**WELWYN HATFIELD BOROUGH COUNCIL
EXECUTIVE DIRECTOR - PLANNING, PUBLIC PROTECTION AND GOVERNANCE**

Application No: 6/2020/0183/LAWP
Location: 2 Waterworks Cottages Northaw Road East Cuffley Potters Bar
 EN6 4RB
Proposal: Certificate of lawfulness for the installation of 1 x dormer with
 Juliet balcony and 3 x roof-lights
Officer: Ms Lois-May Chapman

Recommendation: Granted

12537-P007-B

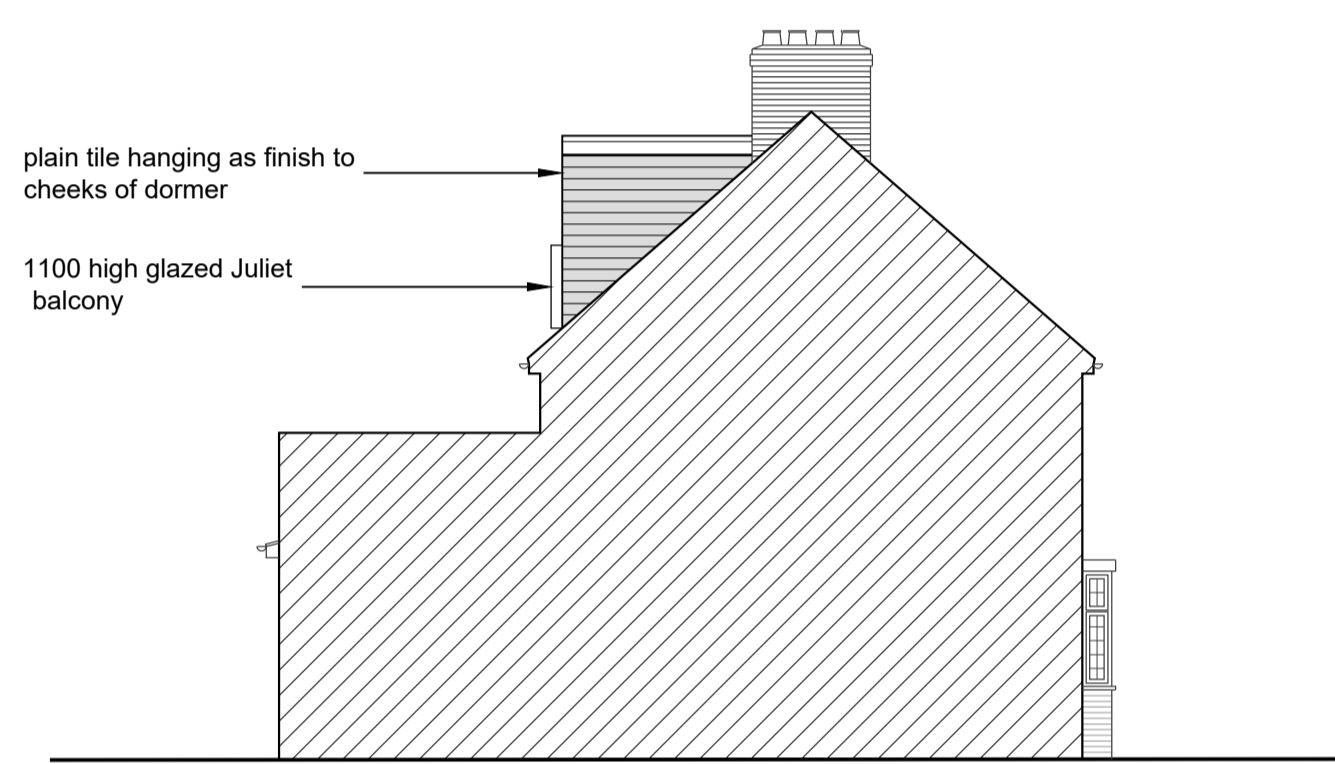
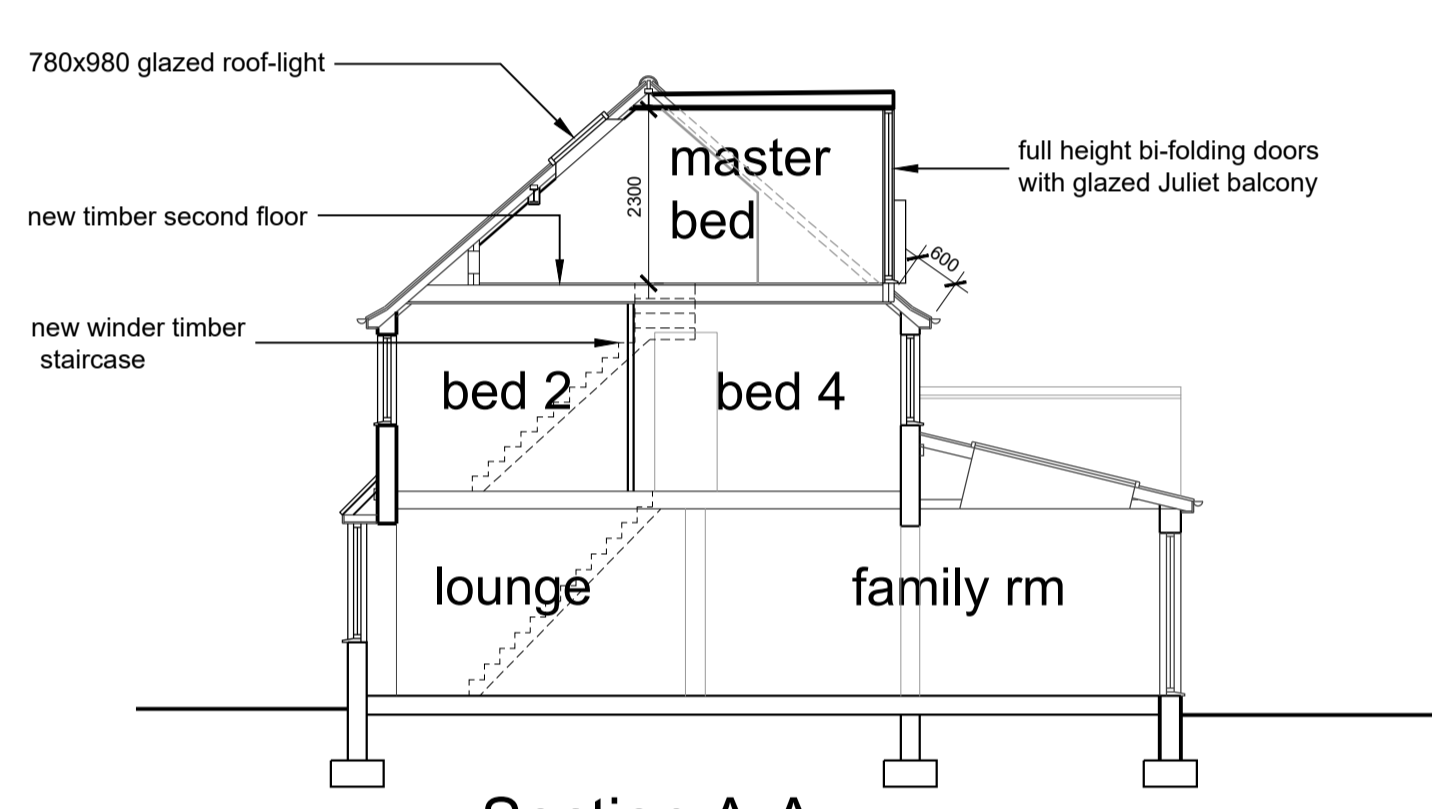
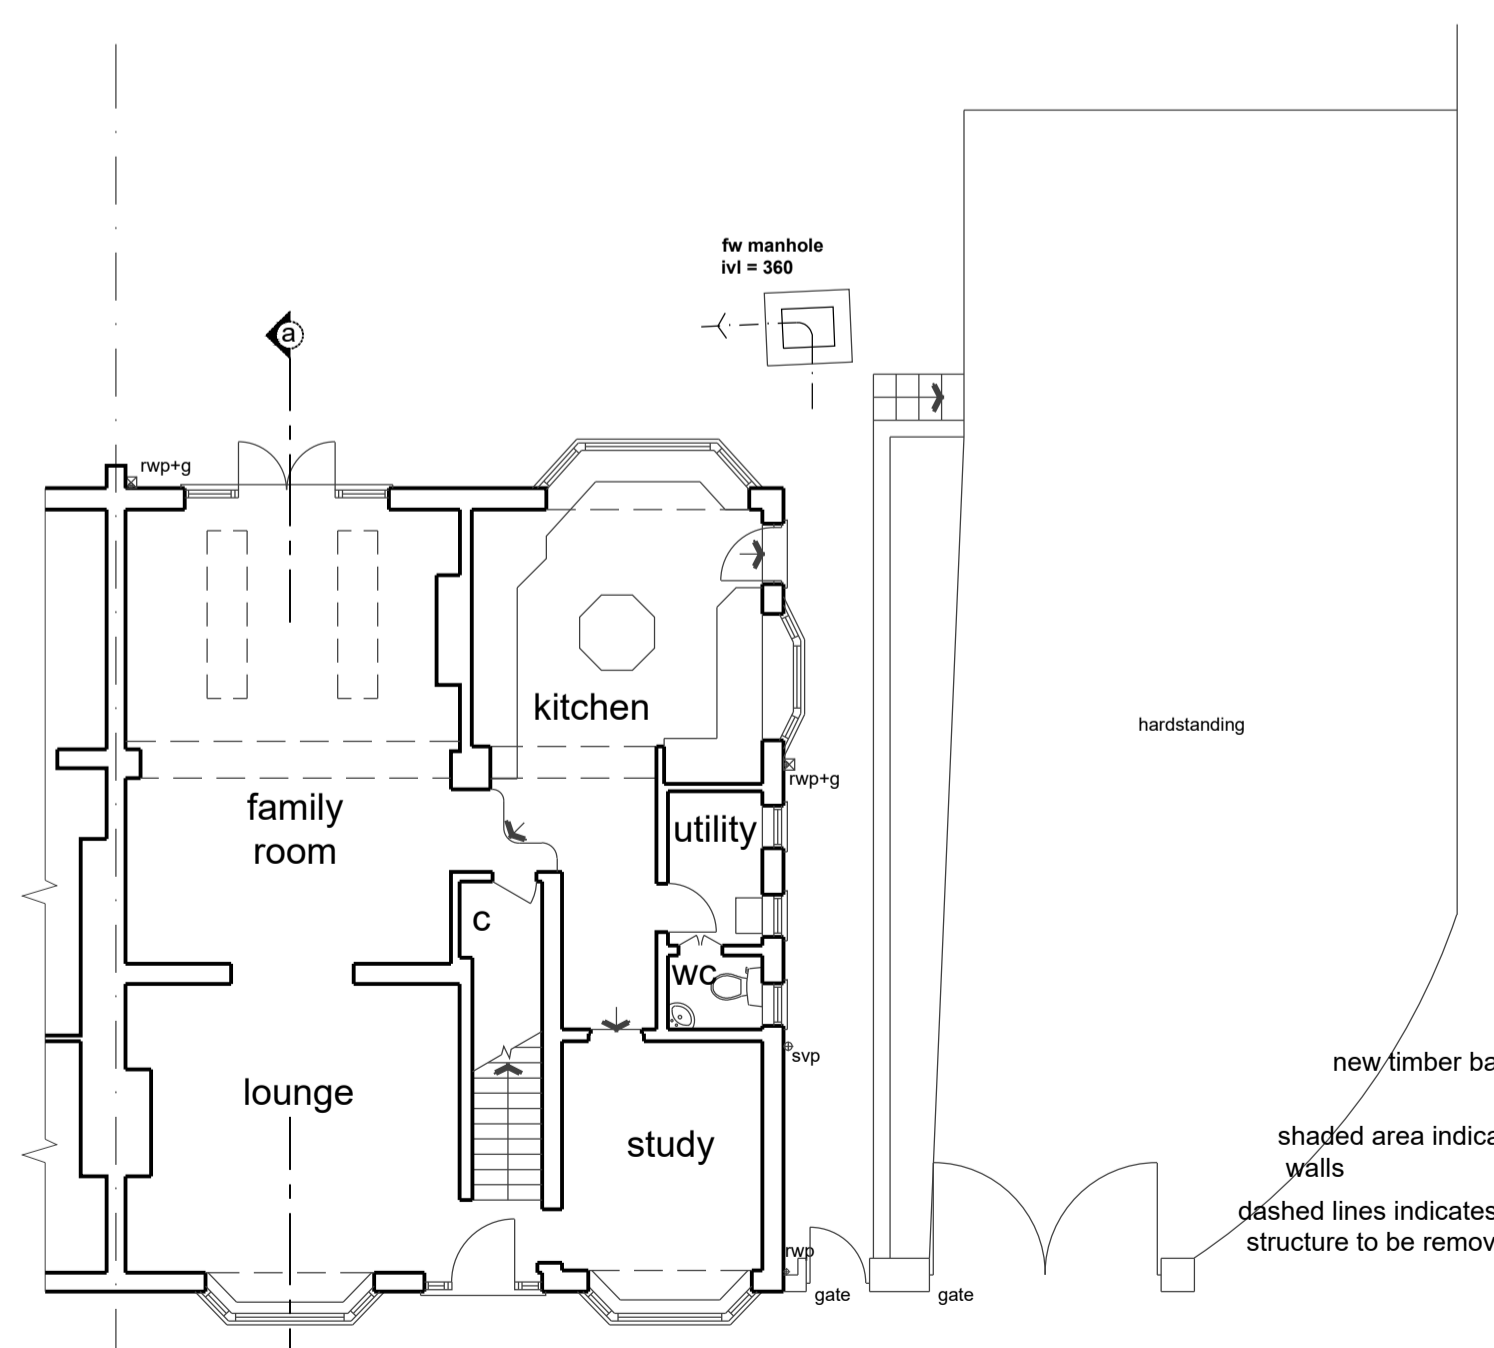
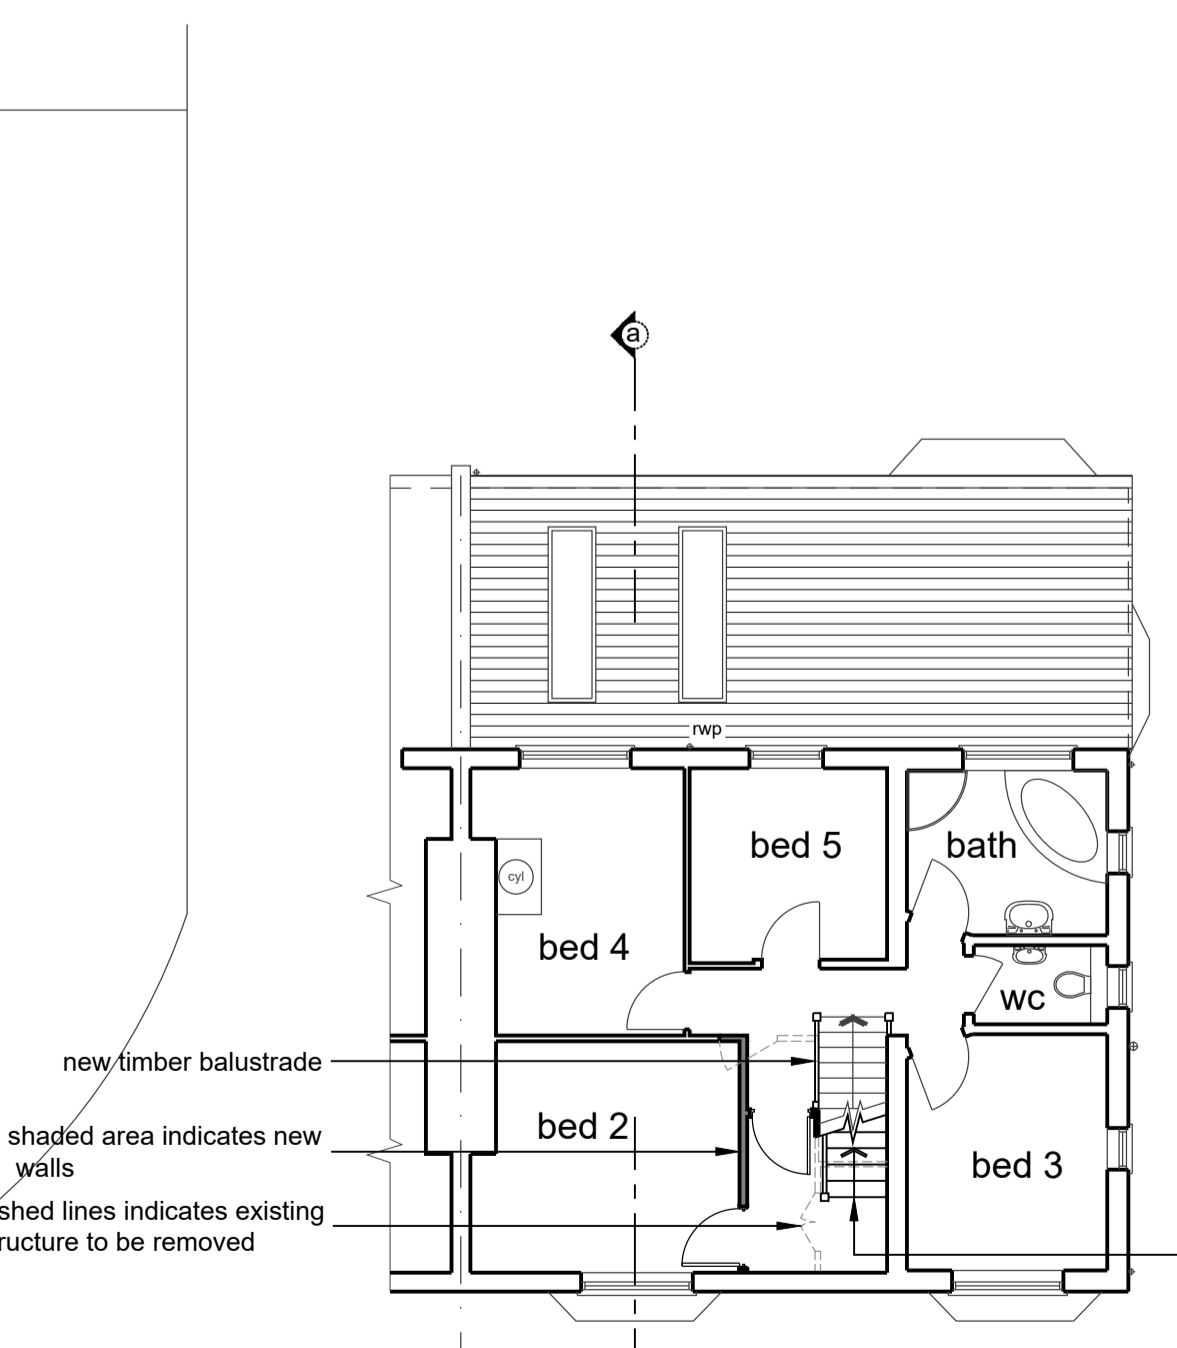
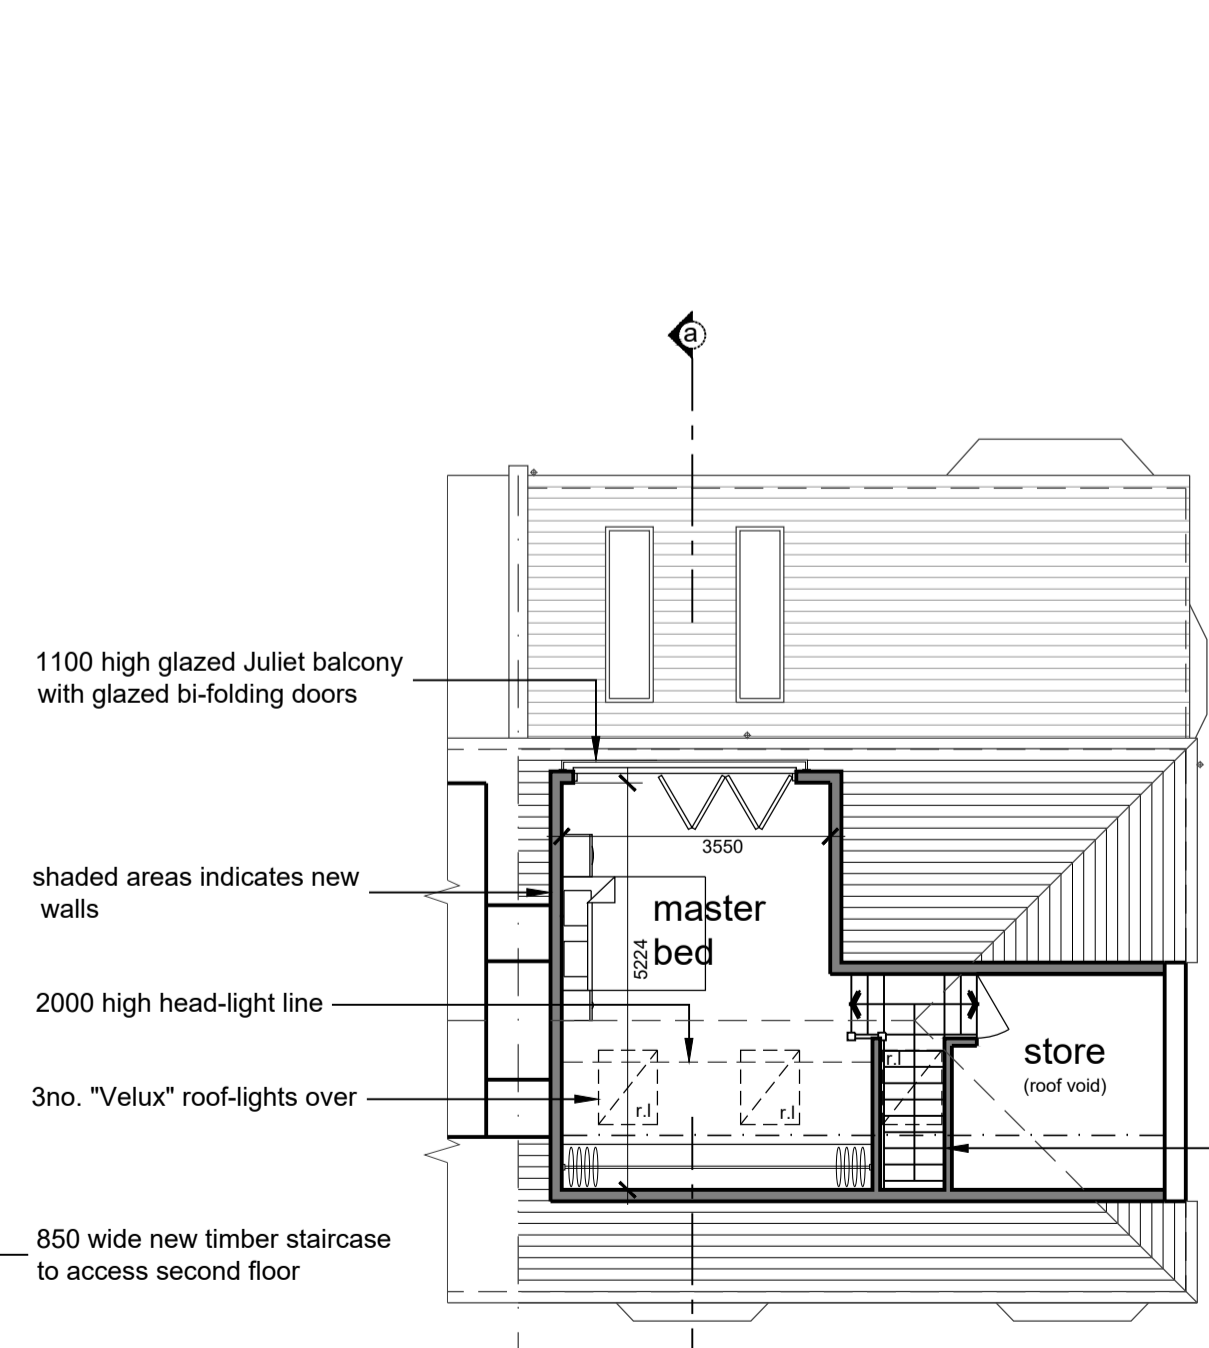
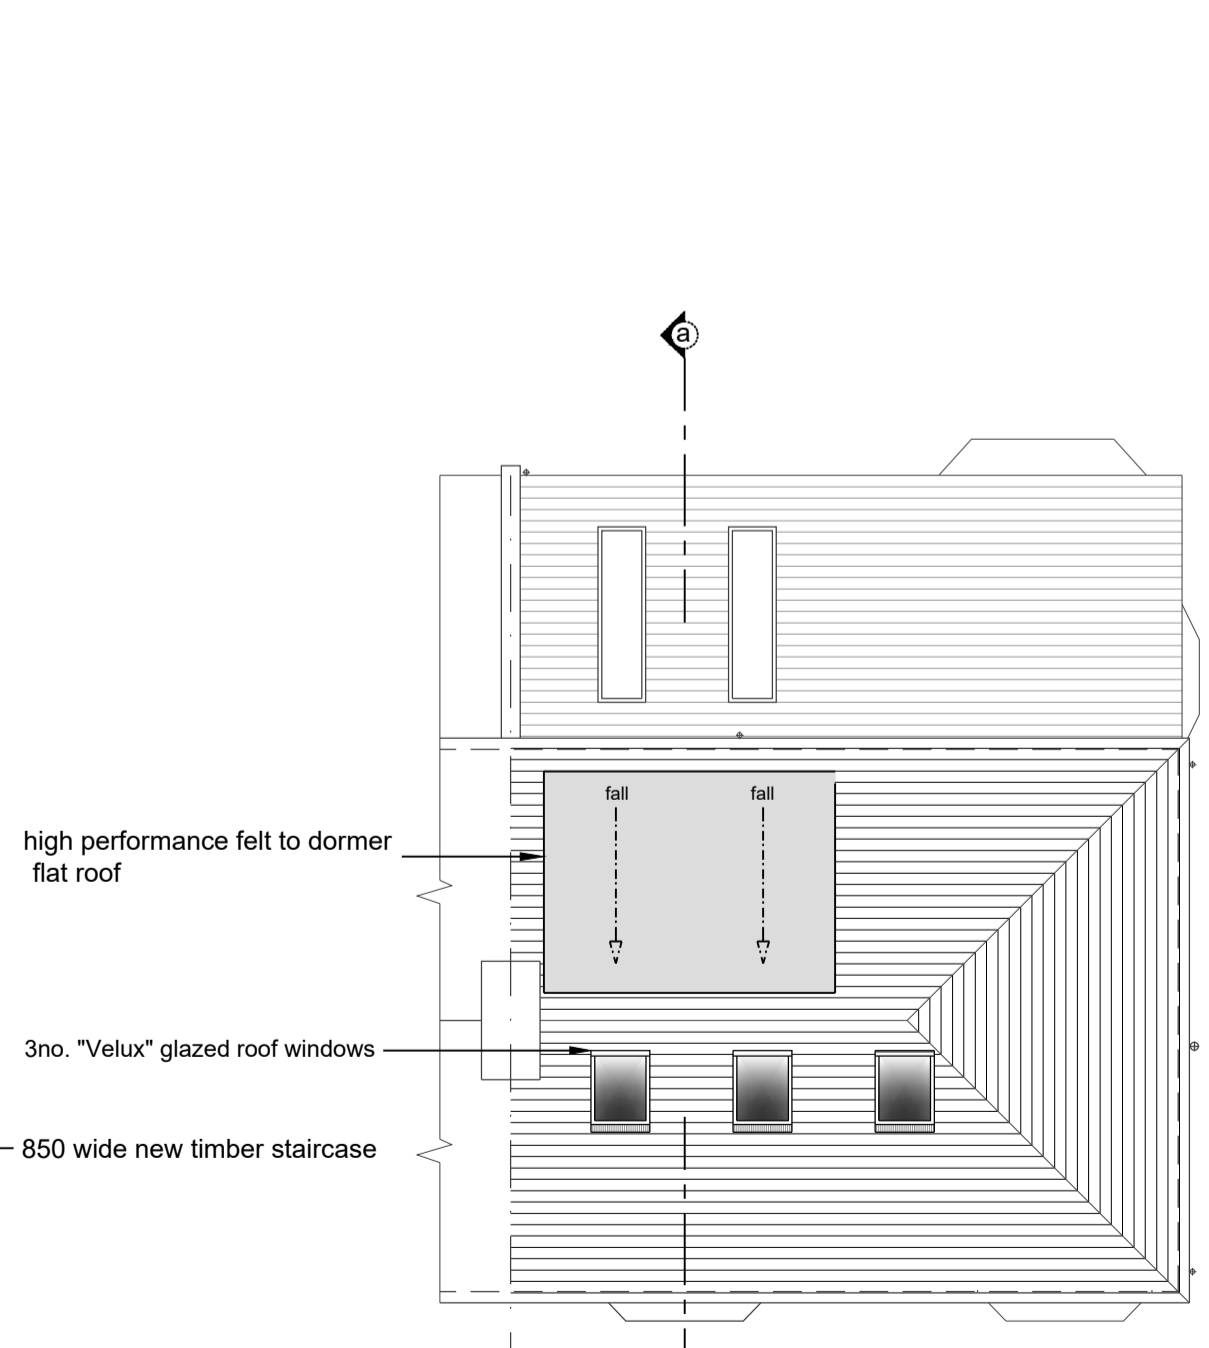
(d) would the cubic content of the resulting roof space exceed the cubic content of the original roof space by more than:- (i) 40 cubic metres in the case of a terrace house, or (ii) 50 cubic metres in any other case	N	N
<p><i>Calculation here:</i></p> <p>The property has previously been extended with a two storey extension granted under application S6/1990/0620/FP which has increased the original roof with a volume of 35.5m³.</p> <p>Dormer volume: $\frac{1}{2} \times 2.9(\text{depth}) \times 2.5(\text{height}) \times 3.8 (\text{width}) = 14.38\text{m}^3$</p> <p>Total volume increase: 49.88m³</p>
